HyNet North West

SCHEDULE OF CHANGES TO THE dDCO

HyNet Carbon Dioxide Pipeline DCO

Document Reference Number D.3.3

**EN070007-D.2.4-WP-Sheet 24**

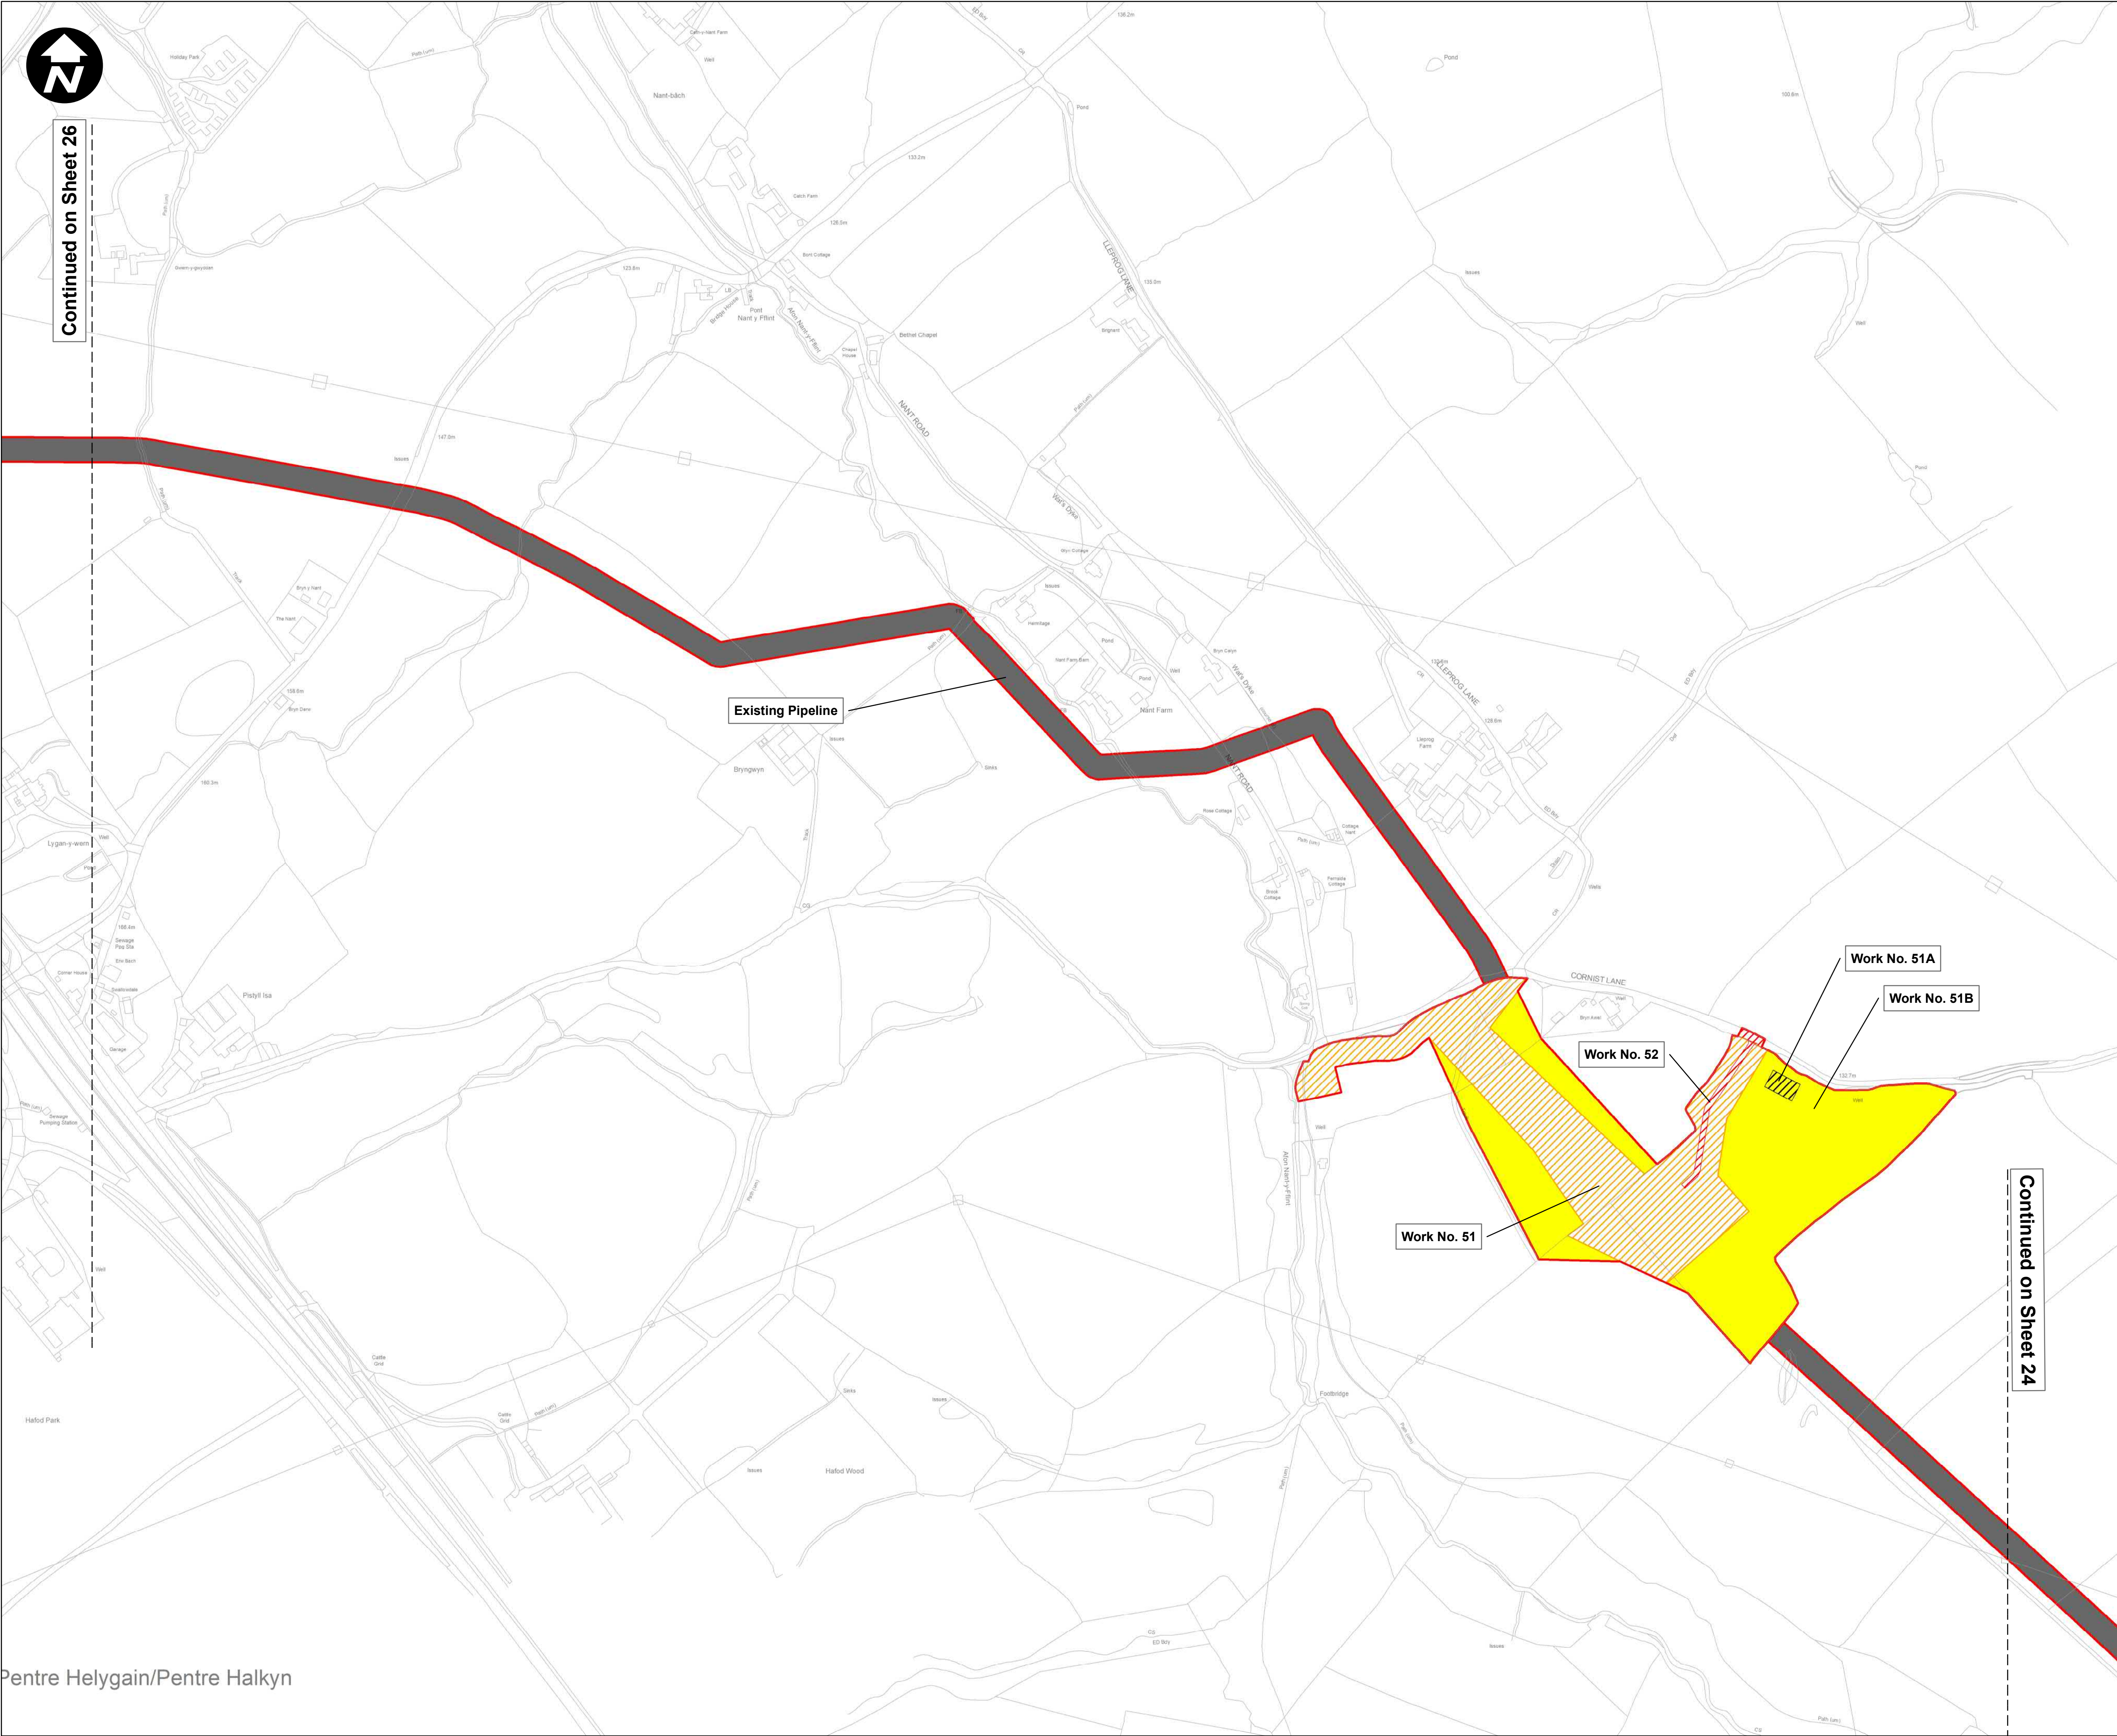
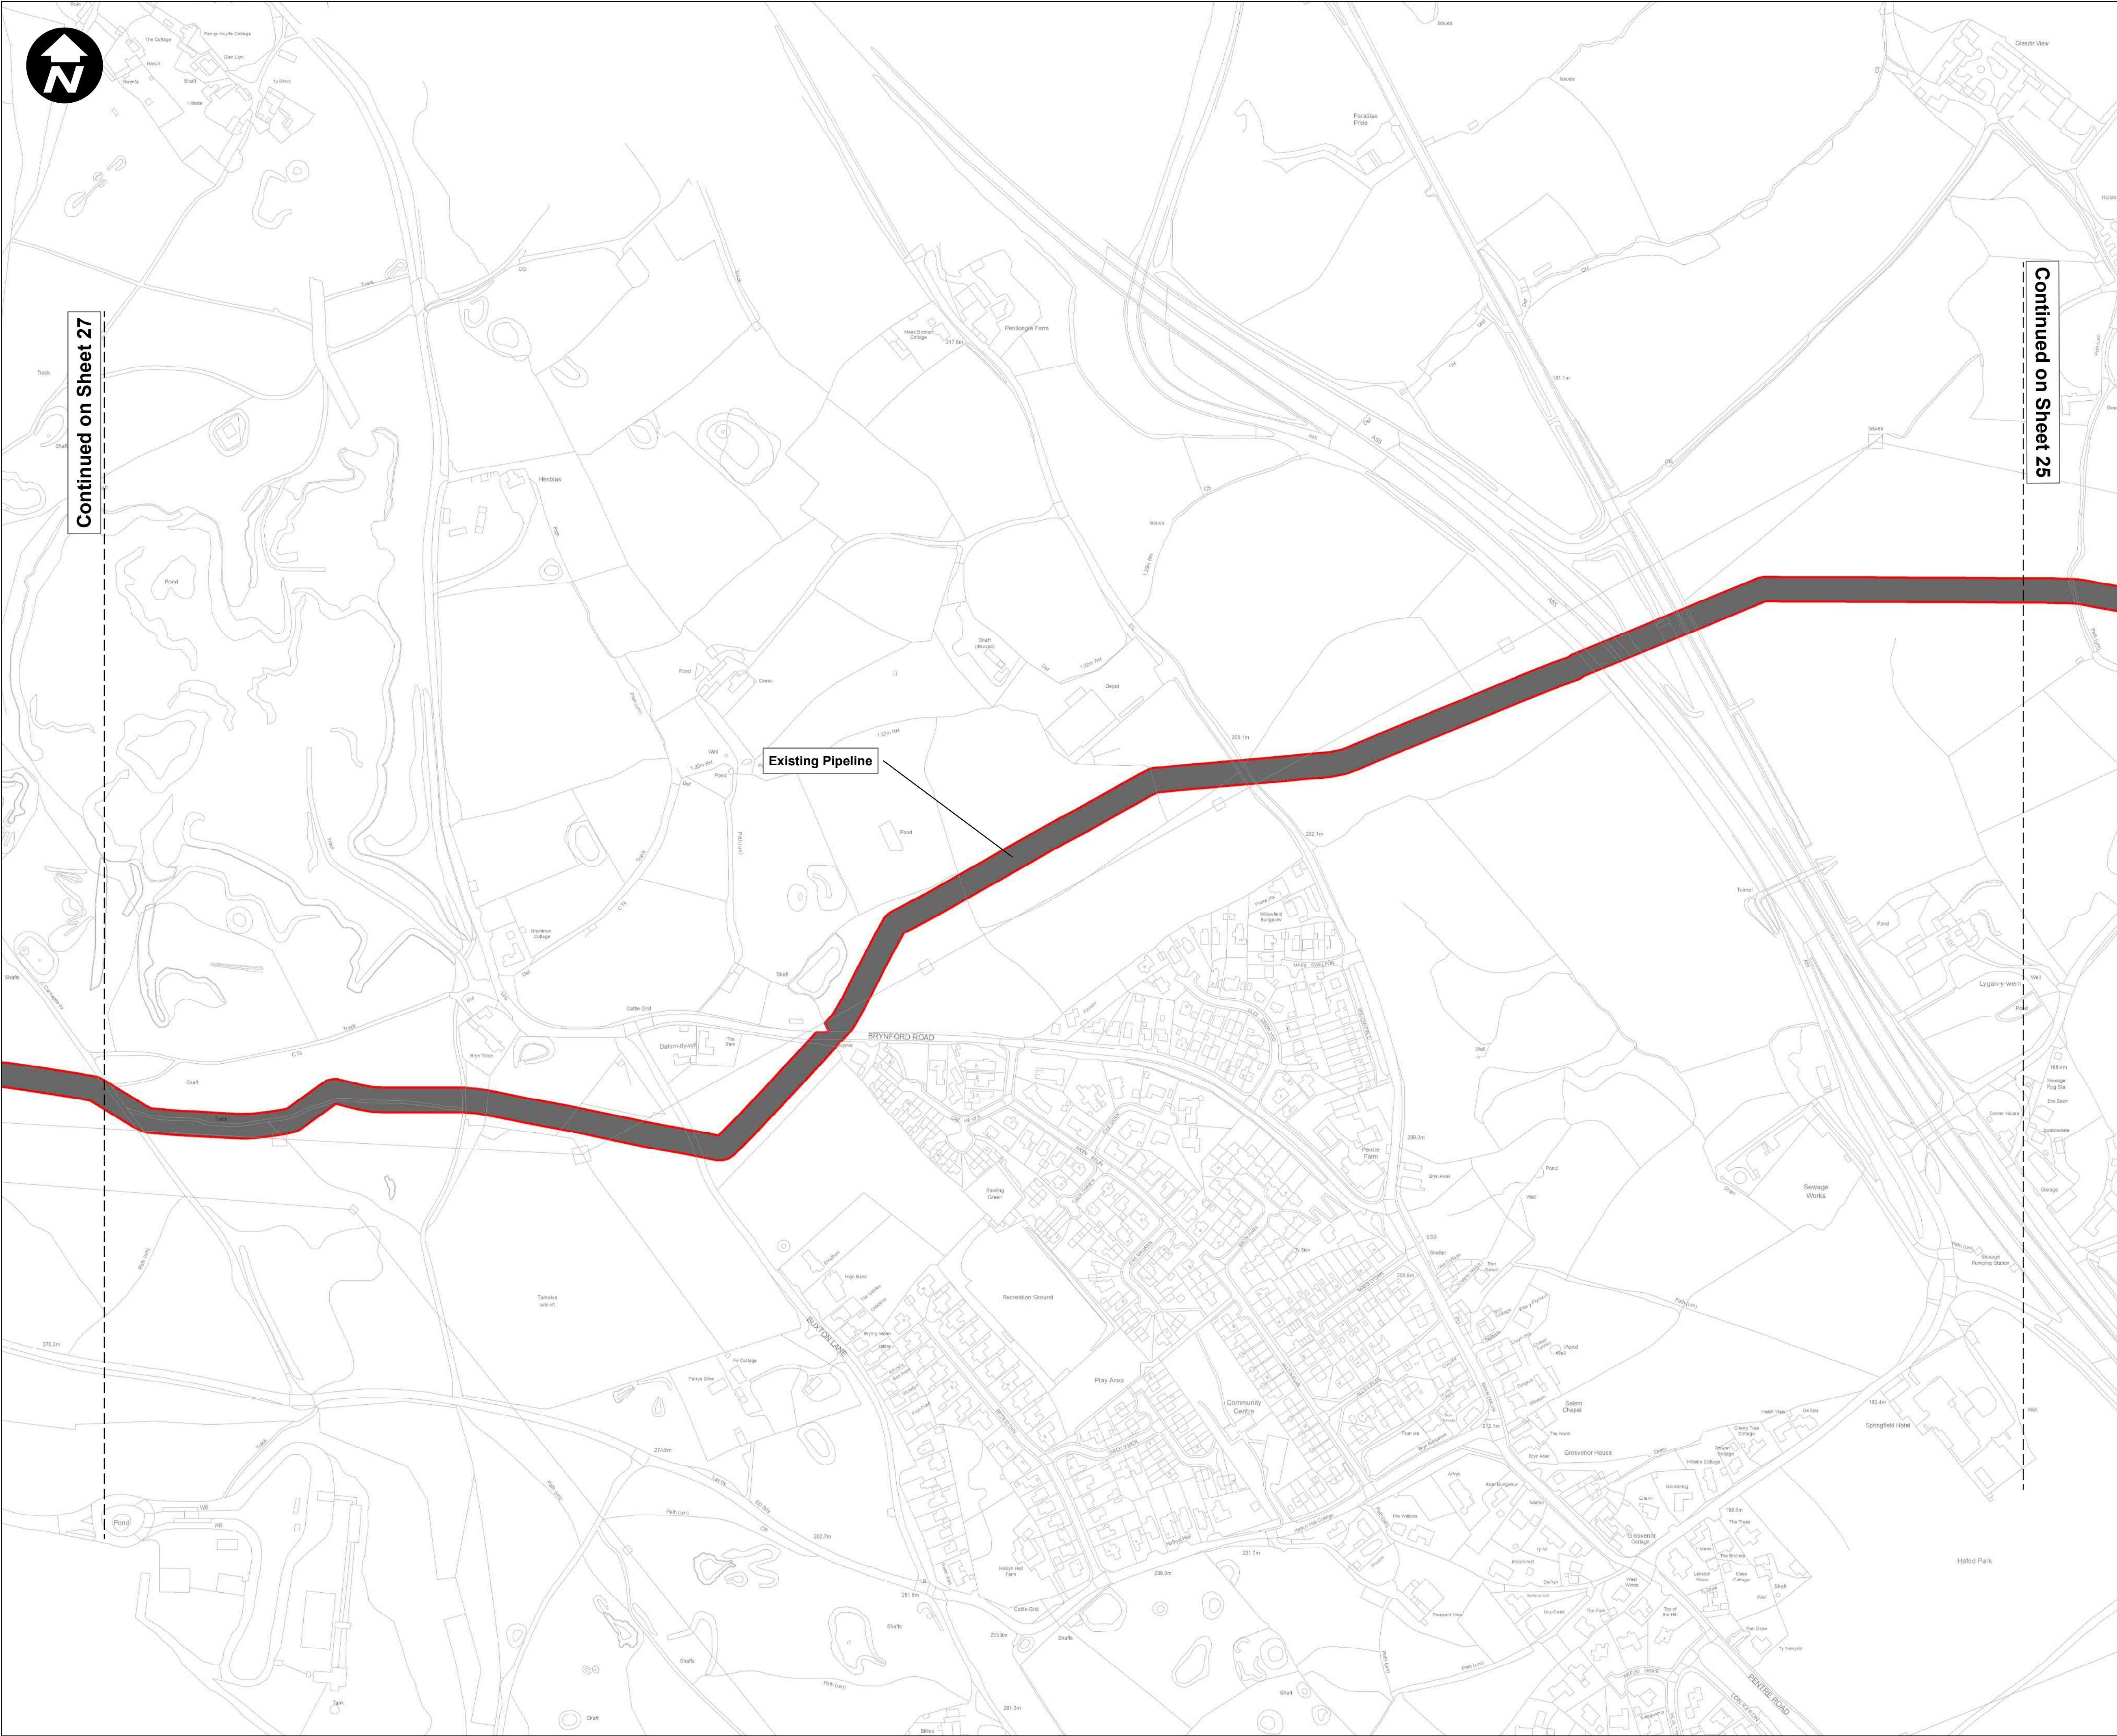
<i>Work No. 51B:</i> The creation and use of a temporary working area for the use during the construction of Work No. 51, within the location shown on Sheets 24 and 25 of the Works Plans	Correction of error
	<i>Work No. 57I:</i> Creation of environmental mitigation west of Aston Hill/east of Shotton Lane Church Lane at the location shown on Sheet 17 and 18 of the Works Plans, including—	Amended in response to a question, in order to clarify
	<i>Work No 57M:</i> Creation of environmental mitigation east of Northop Hall AGI west of Work No.44 at the location shown on Sheet 20 of the Works Plans, including – (a) woodland planting; and (b) scrub planting over the pipeline.	Amended in response to a question, in order to clarify
	Added omitted Work No.57	Correction of error
